Subject: RE: Planning Consultation on: BN/5/20/PL

Engineers Comments Regarding Surface Water Drainage

APPLICATION NO: BN/5/20/PL

Site Address: Land north of Sunnyside Cottages Yapton Road Barnham PO22 0AZ

Figure 2: Proposed Drainage Strategy

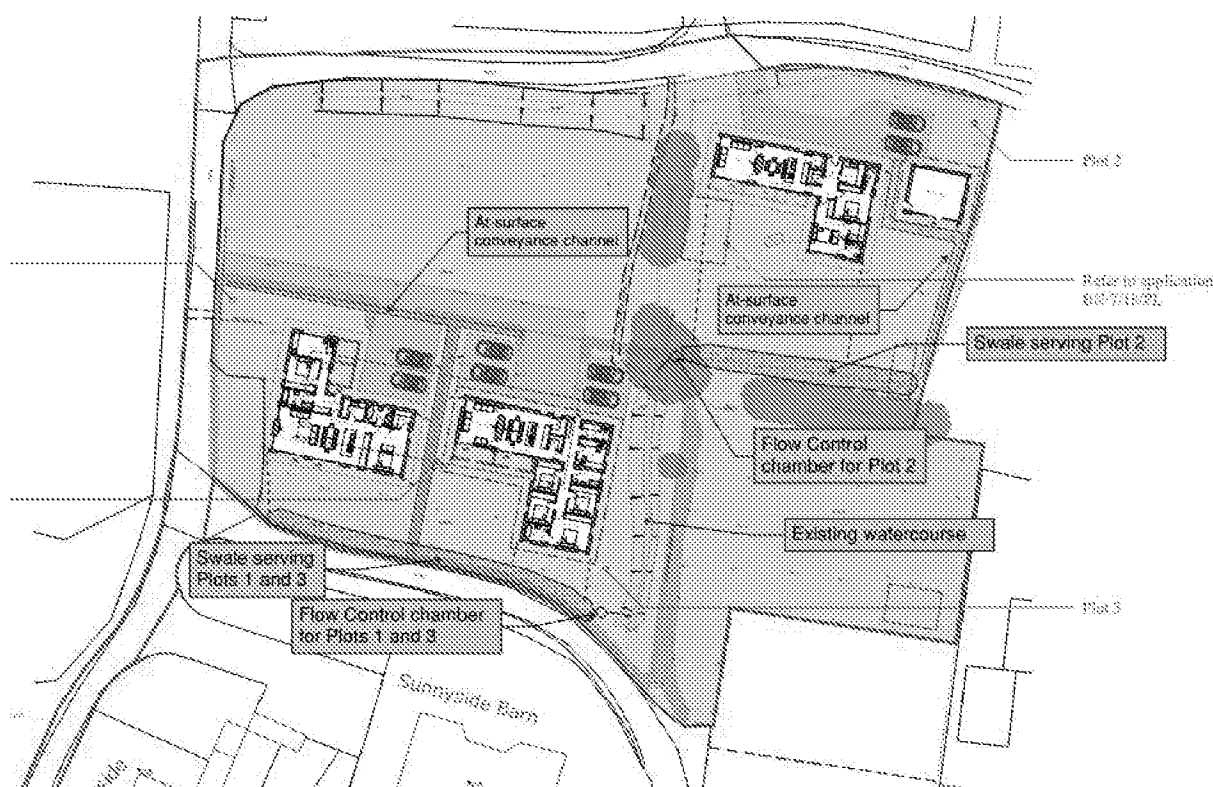
The applicant has supplied a Surface Water Drainage Strategy as part of the application. The principle of the strategy; of attenuating surface water and discharging to the existing watercourse on the site is acceptable, however, this department will require further detail of the proposed scheme. We require a scaled drainage layout, including invert and cover levels and falls, control structures should be labelled with outflow rates, invert levels and design heads. In addition, the applicant should supply construction detail drawings of the proposed swales, conveyance channels, control structures, catch pits/silt traps and the outlets to the watercourse.

1. The groundwater level identified as part of the infiltration testing is unclear. The results state that each pit "filled 60cm within 20mins" from a starting point of 0.9mbgl and 0.7mbgl. On this basis we have read the results as peaking at 0.1mbgl in TP2. (Rather than both pits stabilising at 0.6mbgl). If this is the case the swales will require impermeable liners to avoid groundwater ingress, this will require the design to account for buoyancy. If the groundwater is in fact at 0.6mbgl then the applicant is advised to approach this department to discuss any further required monitoring and/or design options.
2. We do not accept orifices of less than 50mm as control devices due to the risk of blockage causing flooding upstream. On this basis the calculations will likely change with the inclusion of alternative flow control devices.

3. It is not mentioned within the discussion of the impermeable areas, but please ensure that the design accounts for rainwater falling directly onto the swales themselves (and runoff from surrounding areas).
4. A pipe is believed to enter the watercourse at the north end of it, all structures must be kept further than 3m from this.
5. All buildings and fences must be minimum 3m from the top of the ditch bank.
6. The downstream culvert (which the watercourse leads to) has known issues. The applicant will likely need to undertake offsite improvements to this to ensure it is fit for purpose. The same is likely to be applicable for the headwall and ditch onsite.
